11 July 2016

RE: Section 75W Modification Application (MP08_0241 MOD 5)
100 Mount Street, North Sydney

I refer to your request for traffic comments in relation to proposed modifications to 89-96 & 100 Mount St, North Sydney (MP 08_0341 Mod 5). I have reviewed the proposed modifications in relation to changes to provisions for car parking, bicycle parking and motorcycle parking.

drawing Plan - B6 Level

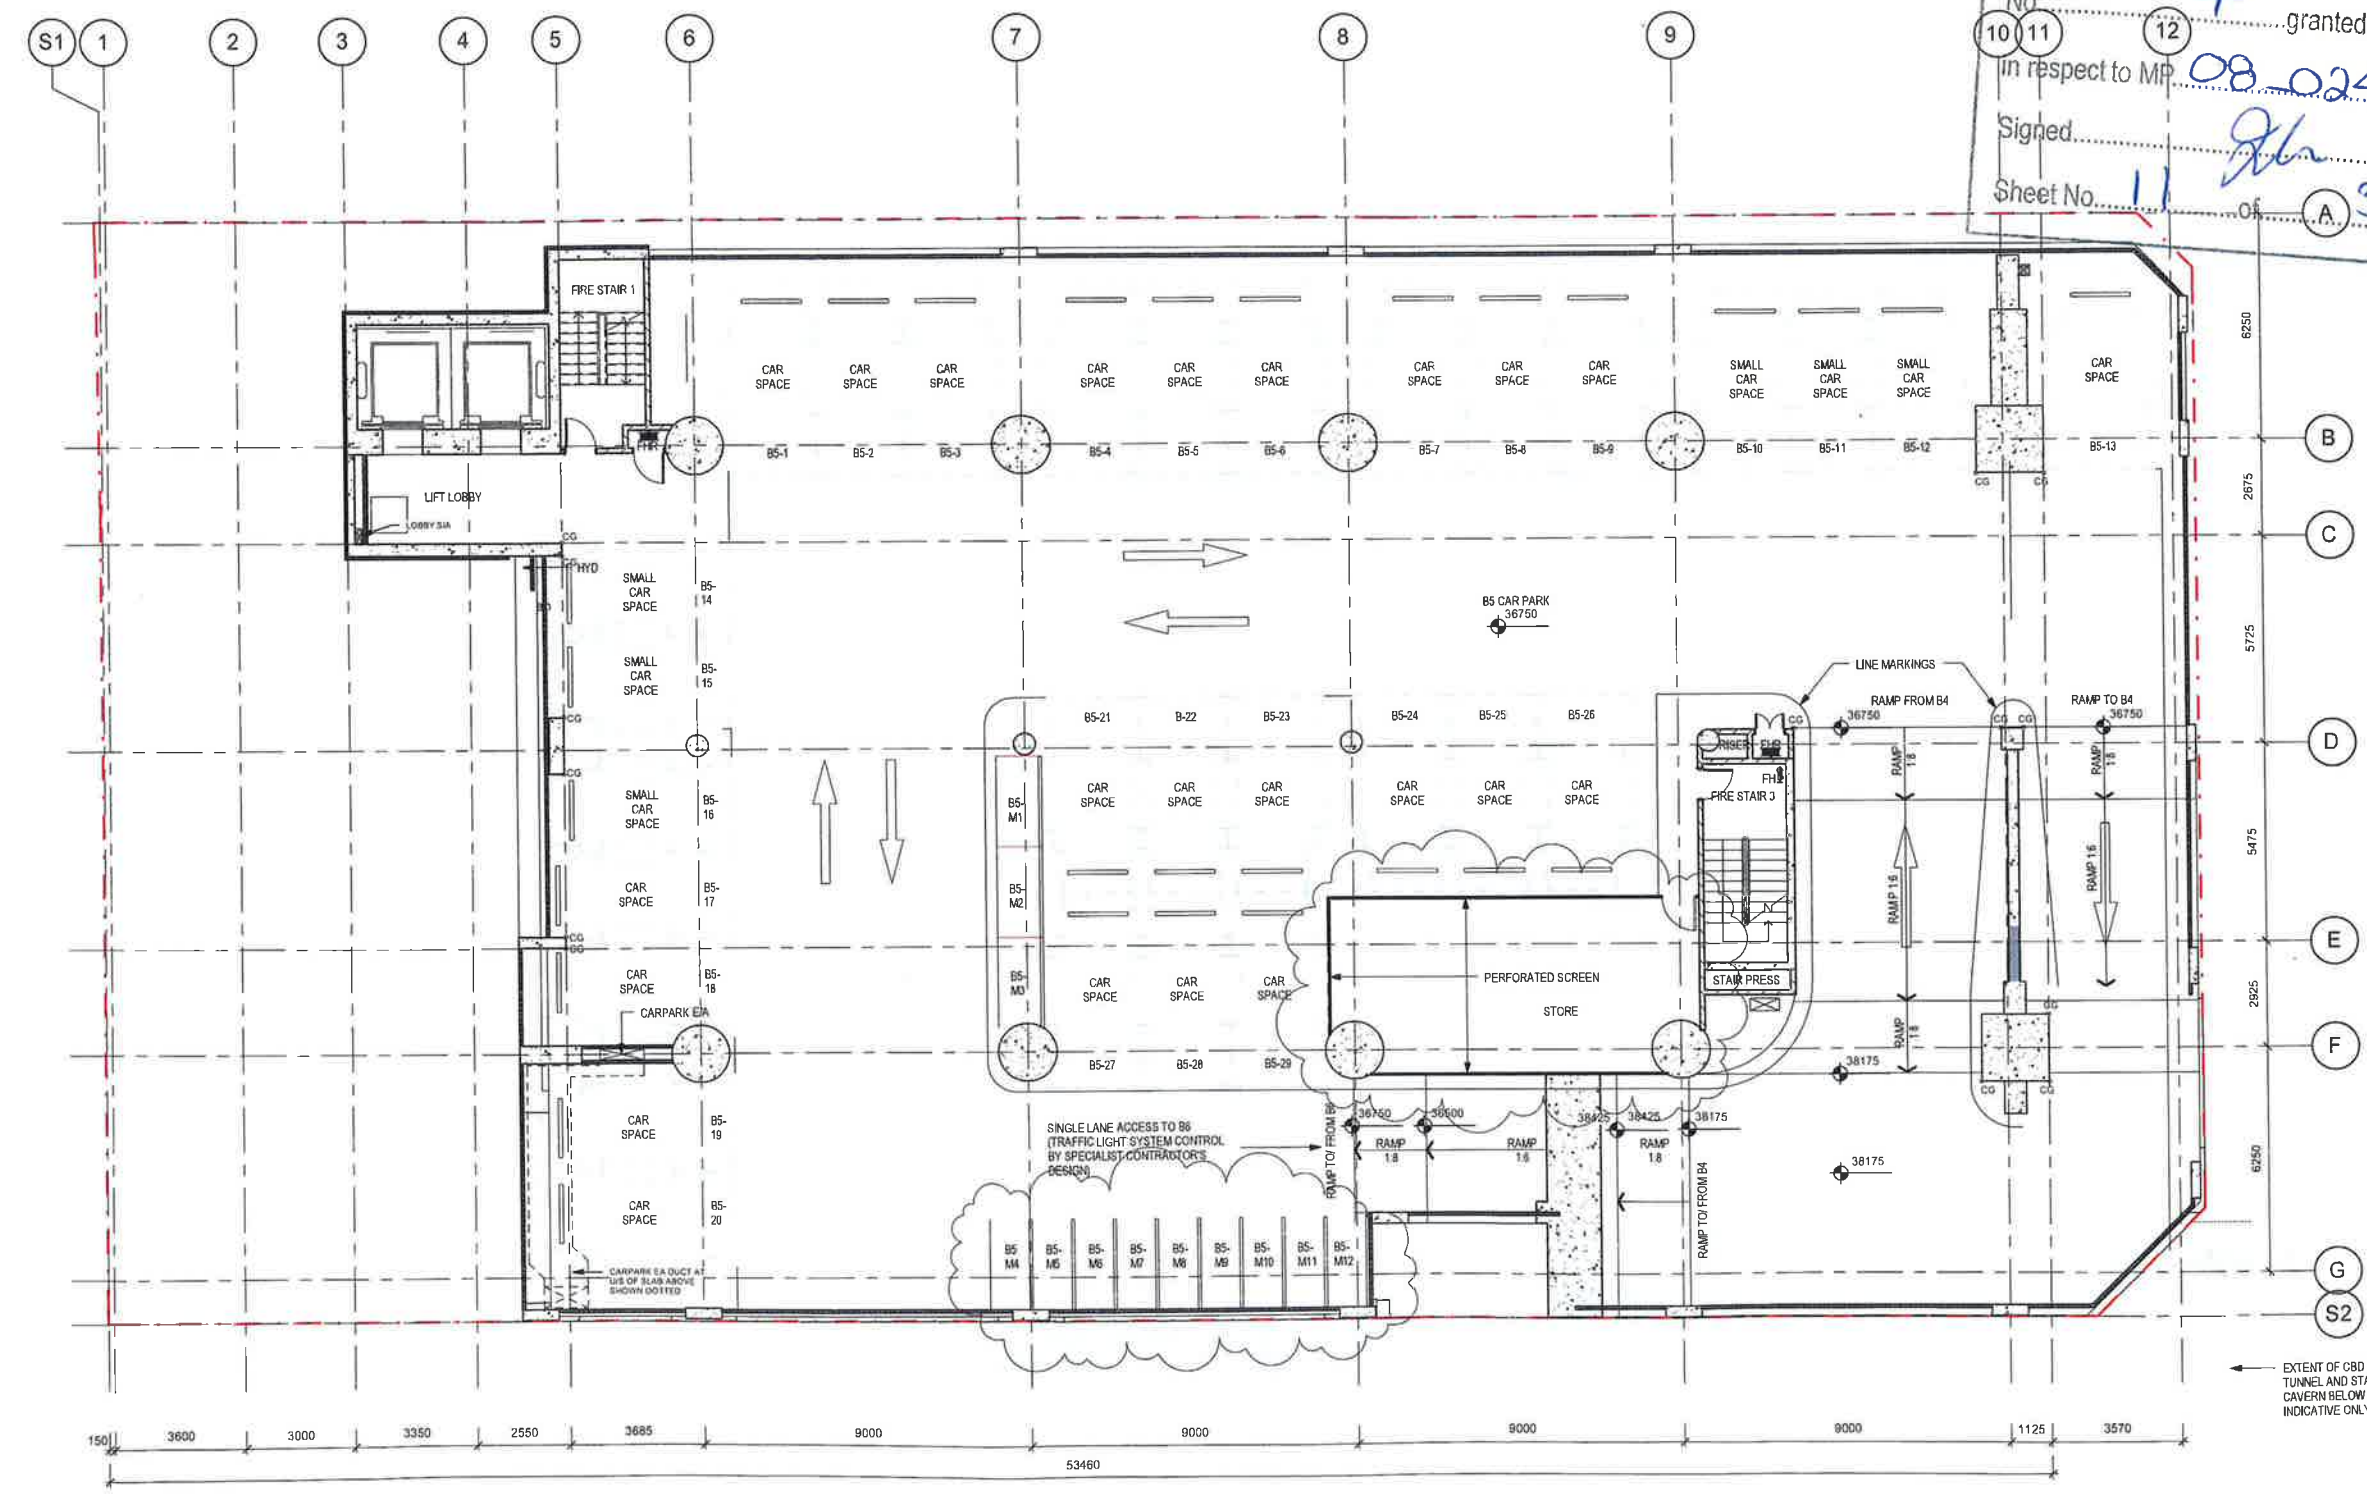
There is a significant undersupply of bicycle parking in the proposed modification. It is acknowledged that the original development application would have been assessed under the former 2002 DCP and exceeded the requirements for bicycle parking at that time. However Council has reviewed the bicycle parking rates in accordance with best practise ESD to support and encourage sustainable transport options as alternatives to the private motor vehicle. Under the current 2013 DCP the proposed modifications actually require an increase of 7 bicycle parking spaces. The reduction of bicycle parking by 29%, particularly for a significant commercial development in the heart of the North Sydney CBD, will undermine the intent of the DCP and Council's transport policies. It is strongly recommended that the approved 330 bicycle parking spaces be retained.
